16-09-13

Ref: R/190/13/1 - The Vacant Plot to 2 Broadmark Way.

I wish to voice my objection to this planning application for a 3-bedroom house to be built on land to the rear of 20 + 22 Broadmark Lane, accessed via Broadmark Way.

DRAWING TITLE
SITE LOCATION AND LAYOUT PLANS

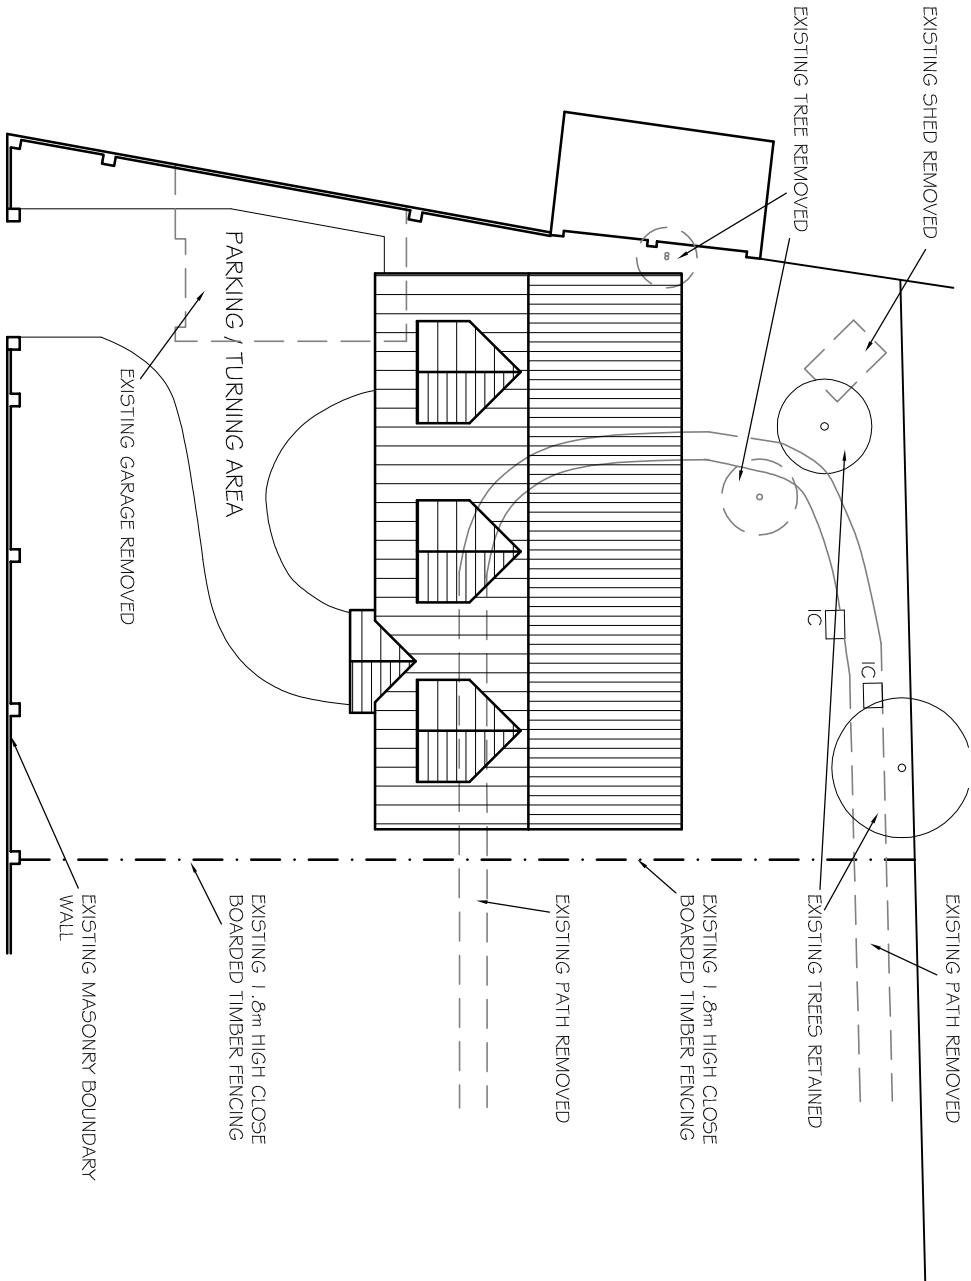
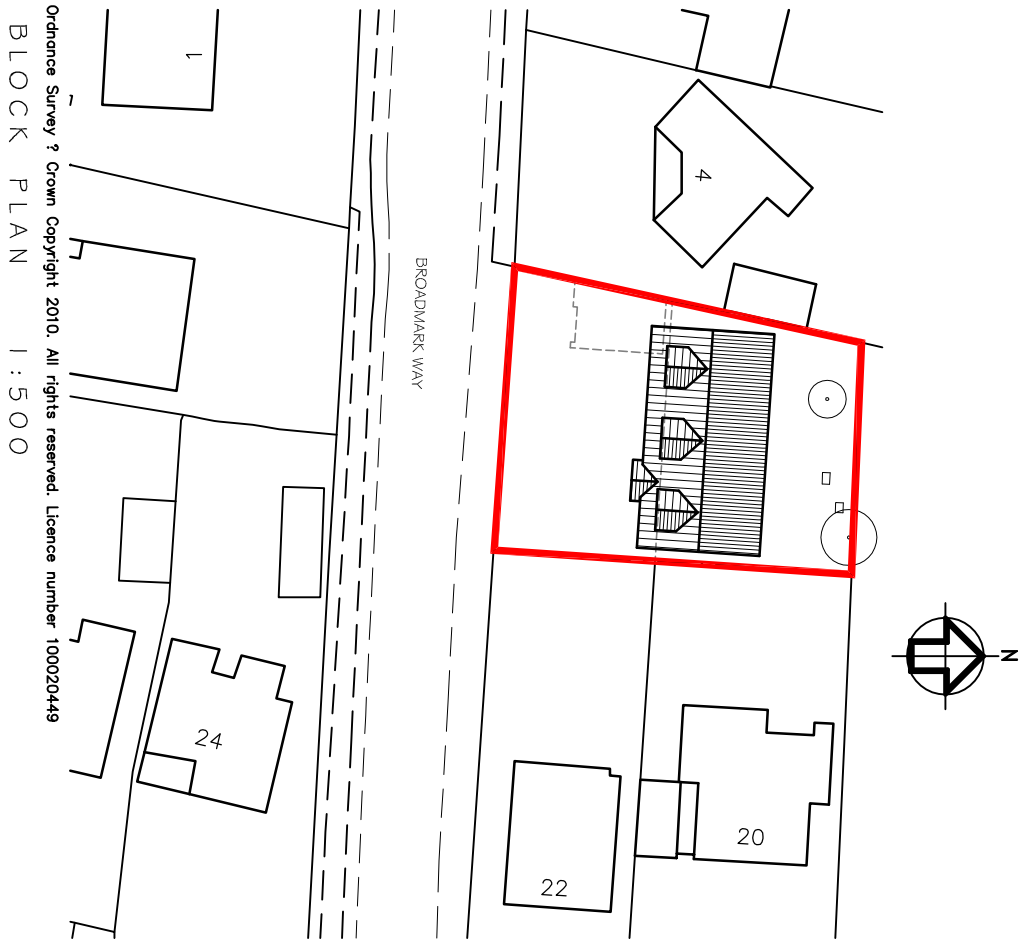
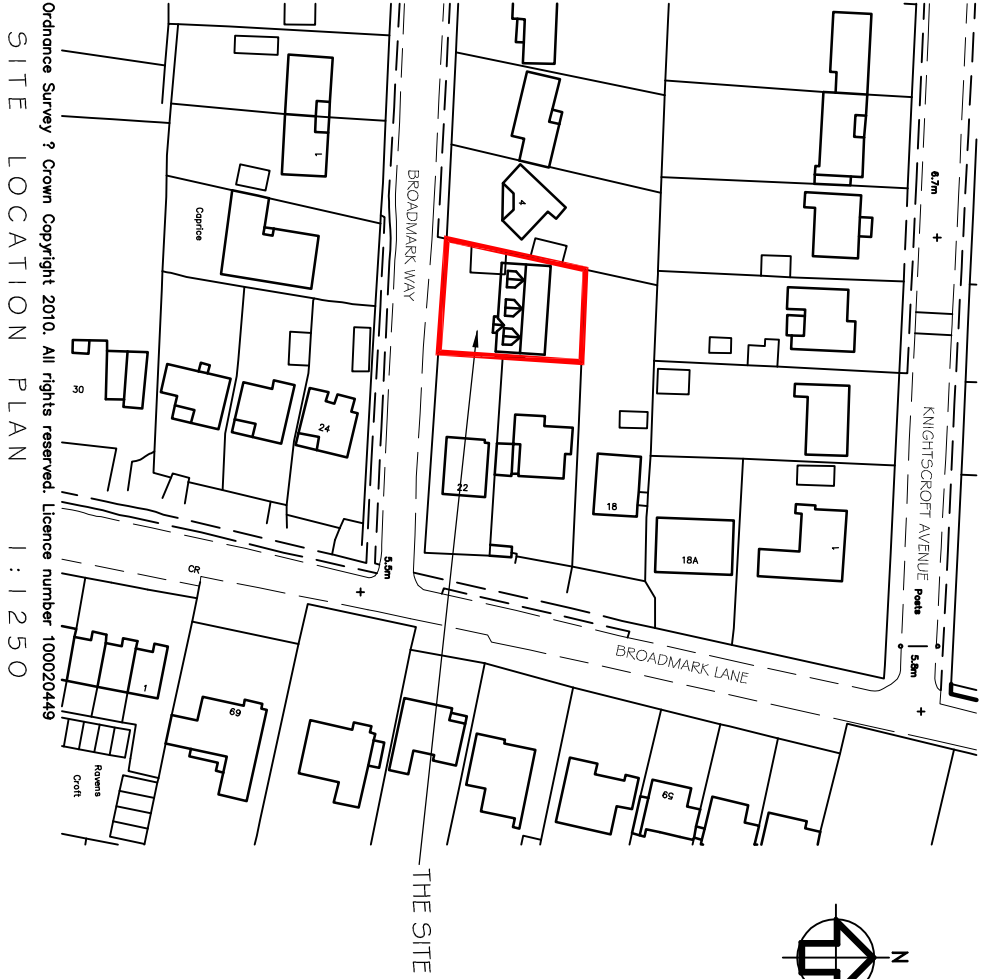
- a) This is for a much larger building than the original proposal for a chalet bungalow and would appear far too large a project for the size of the plot. This plot was purchased from the sale of only 2 rear gardens, whereas the bungalow built on the opposite side of the road (Capric) was built on the site of three previous rear gardens.
- b) This larger house will cause a certain amount of loss of light and privacy to the house & gardens of 18 + 20 Broadmark Lane & 4 Broadmark Way.
- c) The off-road parking does not appear adequate for more than one vehicle and the policy of our Private road is not to allow parking in the road.
- d) Additional strain will be put on the sewage and drainage system.
